The Royal Air Force
Benevolent Fund

Re: Planning Application R/175/12 - No. 46 Seafield Road, Rustington, BN16 2JQ

On behalf of the RAF Benevolent Fund who run and own Princess Marina House, Shencot and Seacot we would like to raise a number of objections in relation to the above Planning Application: -

SOUTH [front] 1/100

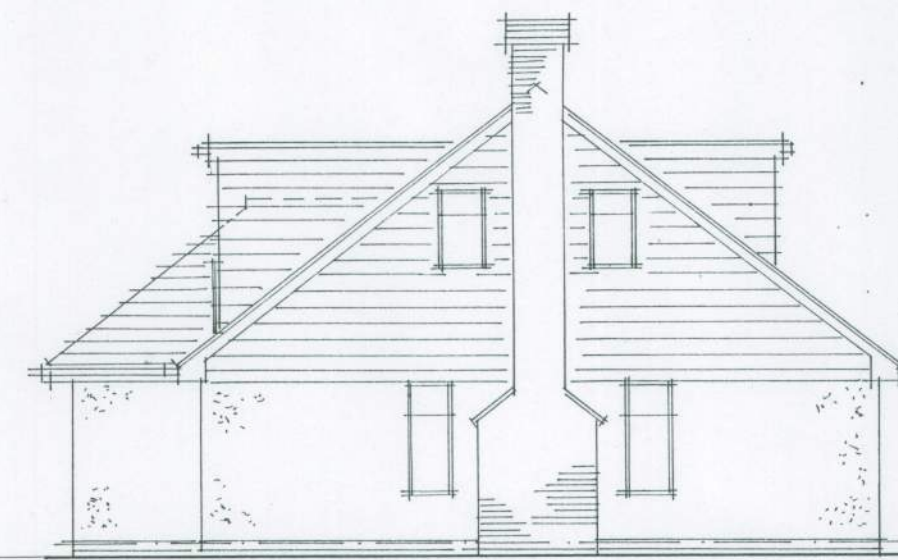
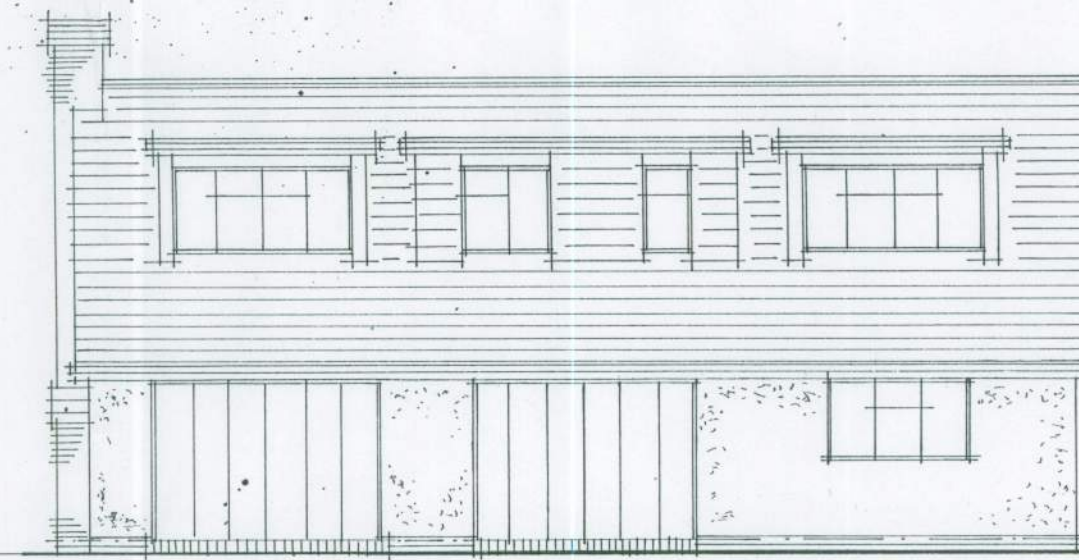
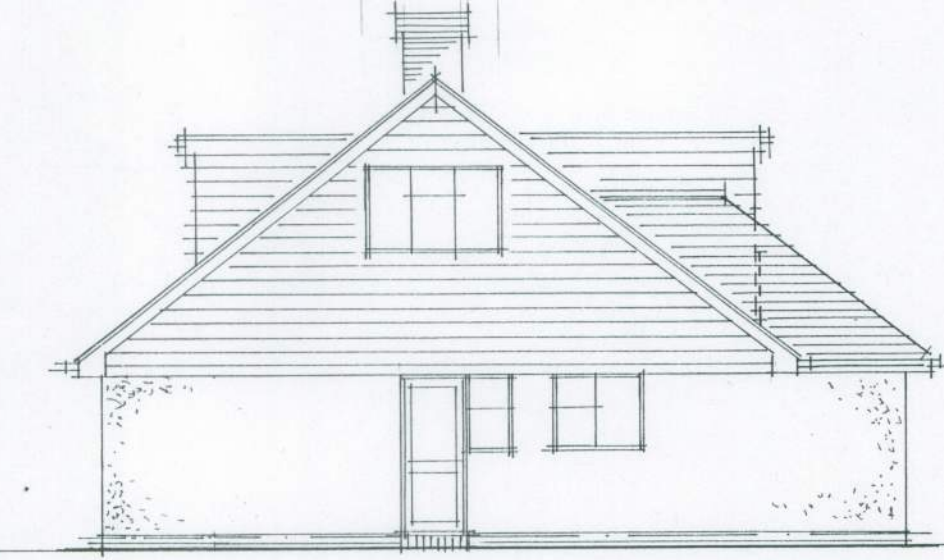
2. The amenity of Shencot (No.44 Seafield Road) is considerably affected, particularly in terms of privacy, with the First Floor bedrooms of the proposed dwelling overlooking the rear of the Benevolent Fund's property. In addition there are concerns with the loss of Daylight due to the close proximity of the gable of No. 46 which is now located tight to the boundary and will if constructed stand 6.00M high.

4. Apart from the positioning of the proposed dwelling on the site we are concerned that the ridge height of the proposed dwelling is 6.00M when compared with the existing dwelling height of 5.70M.

SITE/ROOF PLAN 1/200

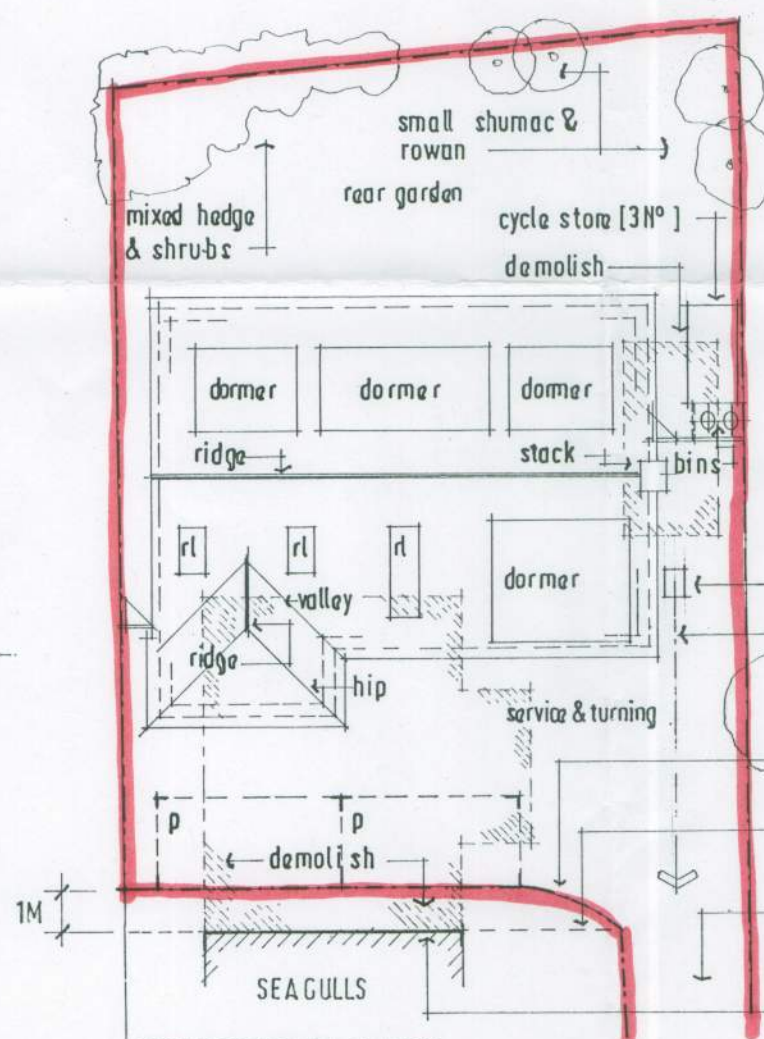
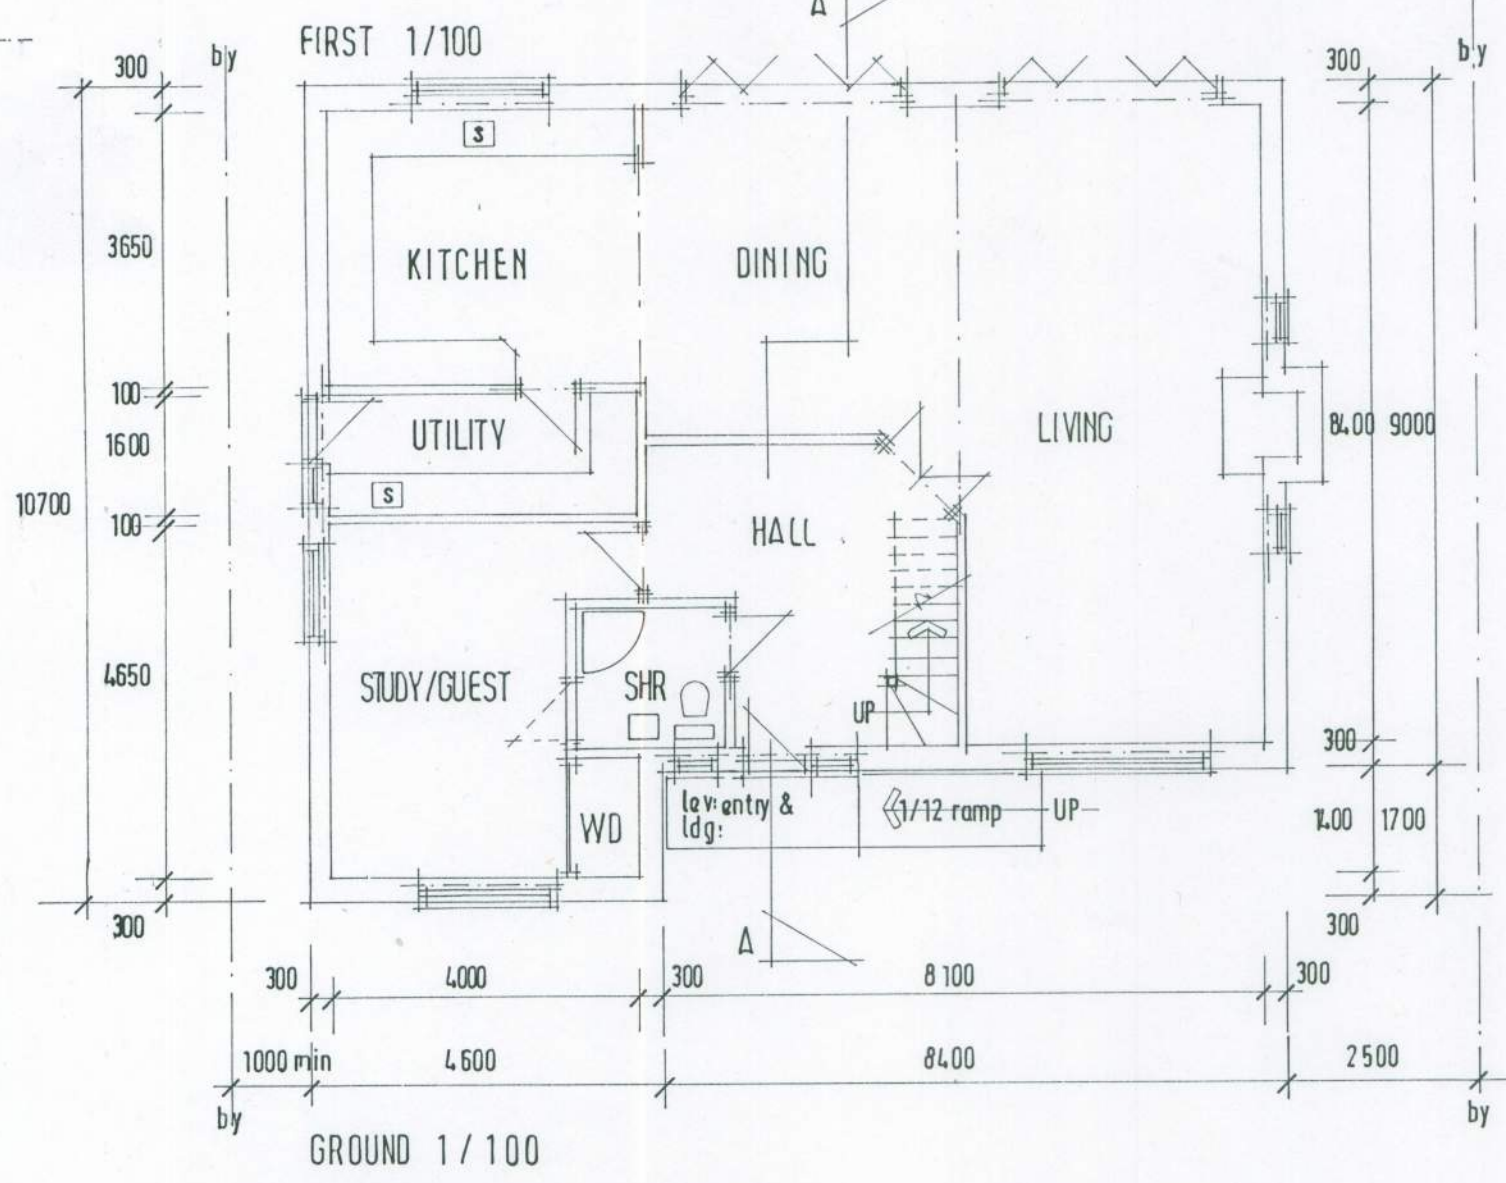
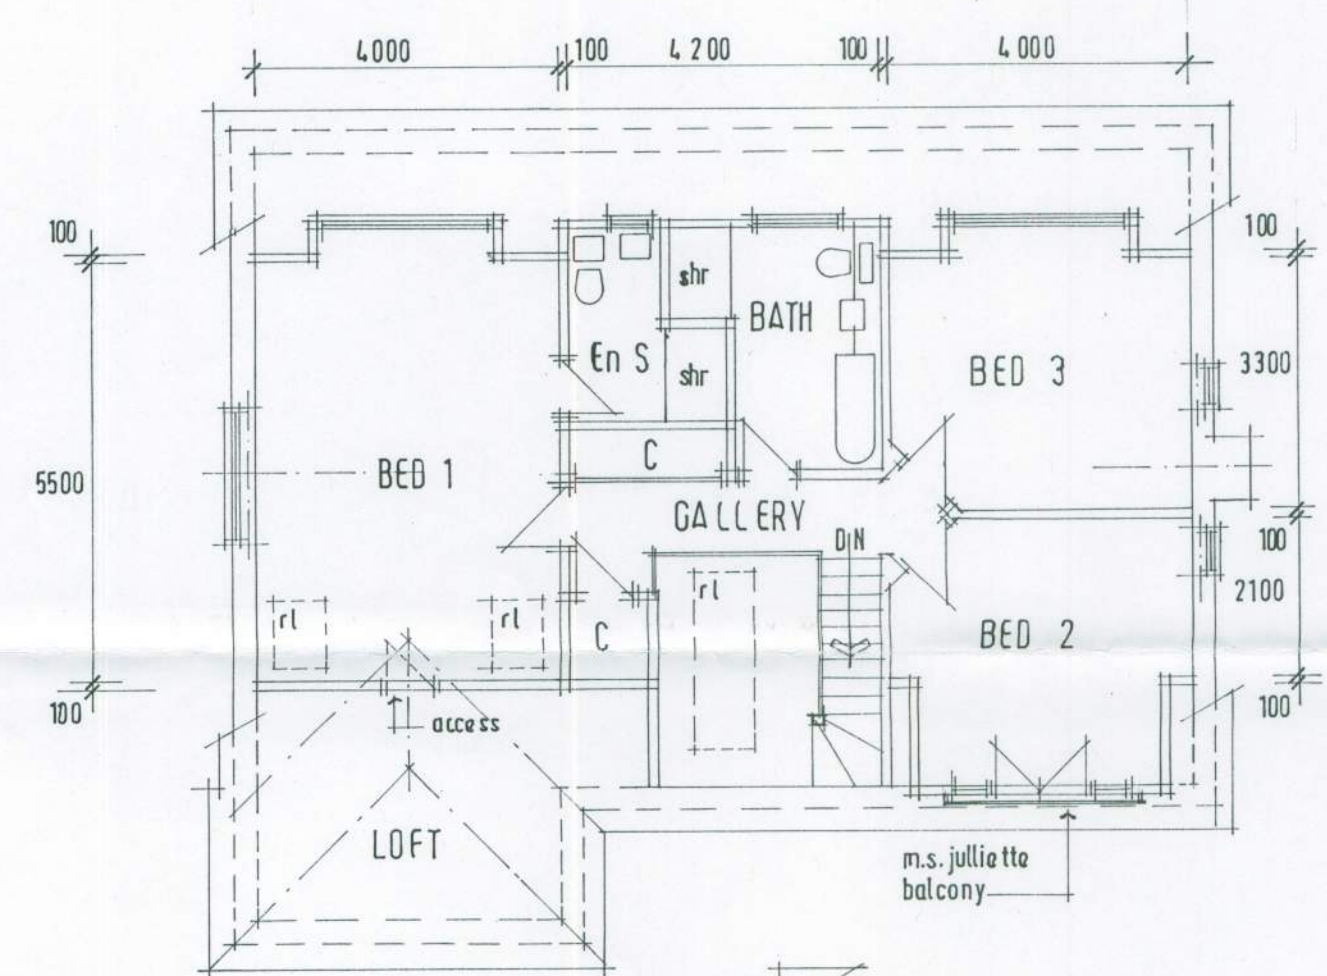
1. The development in our opinion is an overdevelopment of the current site in relation to the surrounding buildings. The existing building is a relatively semi-detached single storey retirement/ holiday bungalow whereas the proposed development is a large detached two storey family home which is built tight to the West and East boundaries and leaves little space to the front or rear (South and North) of the site. It is evident that the mass of the development is inappropriate when compared with the surrounding area.

SCHEMATIC OF NO 46 TO BE DEMOLISHED 1/200

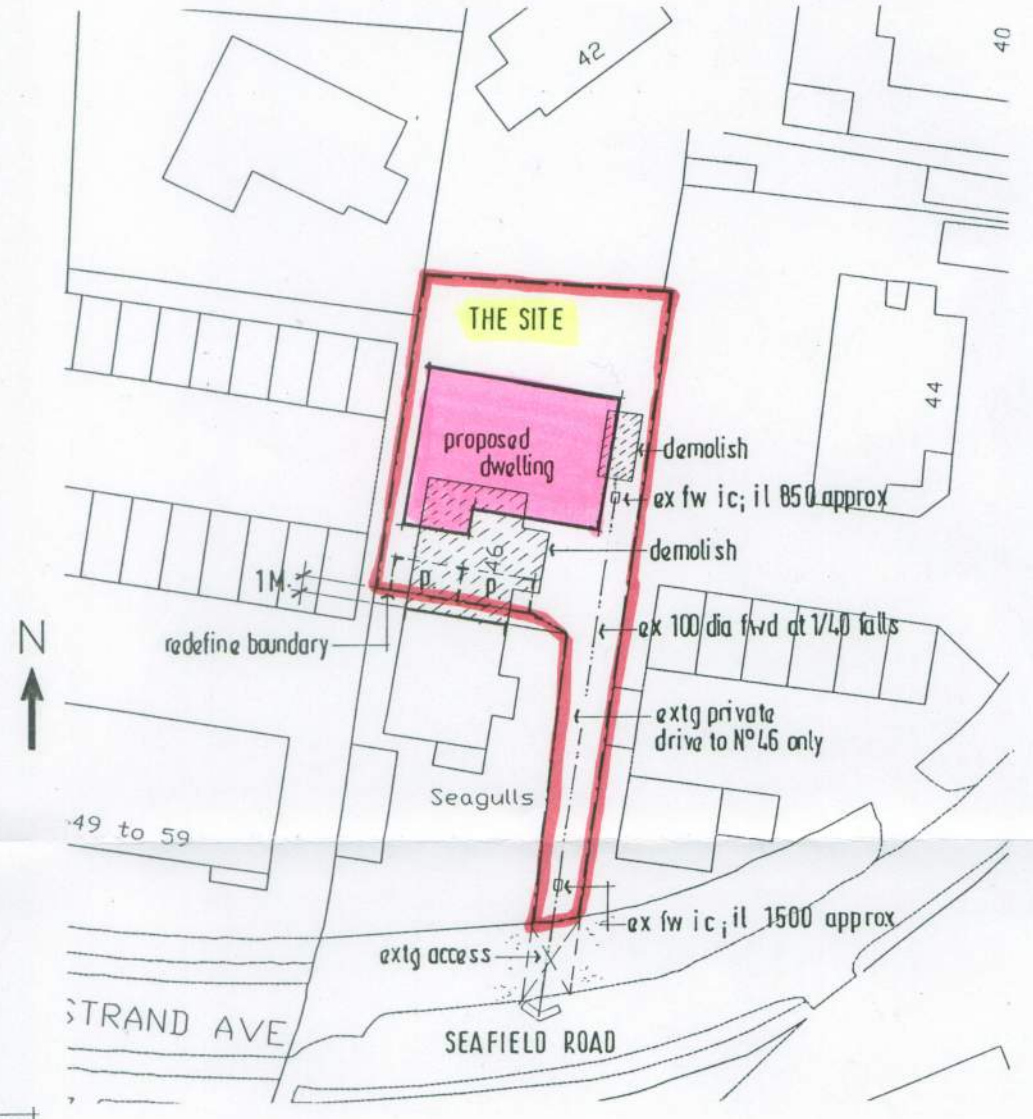
3. The drawing of the existing building cannot be correct in that it creates the impression that the existing four bedroom dwelling is being replaced with a new four bedroom dwelling. The drawing of the existing dwelling has no kitchen and so in fact it is at most a three bedroom dwelling. It is interesting to note that the GIA (Gross Internal Area) of the proposed dwelling is in excess of 2,050ft² compared to the existing dwelling which has a GIA of approximately 650ft². Interestingly the Ground Floor GIA comparison is 1190ft² for the proposed dwelling compared with 650ft² for the existing dwelling, a 68% increase in footprint. The overall increase in GIA for both floors of the proposed dwellings compared with the existing dwelling represents a 215% increase in area. Quite simply this demonstrates that the proposal is inappropriate and, as mentioned above, is an overdevelopment of the small site.
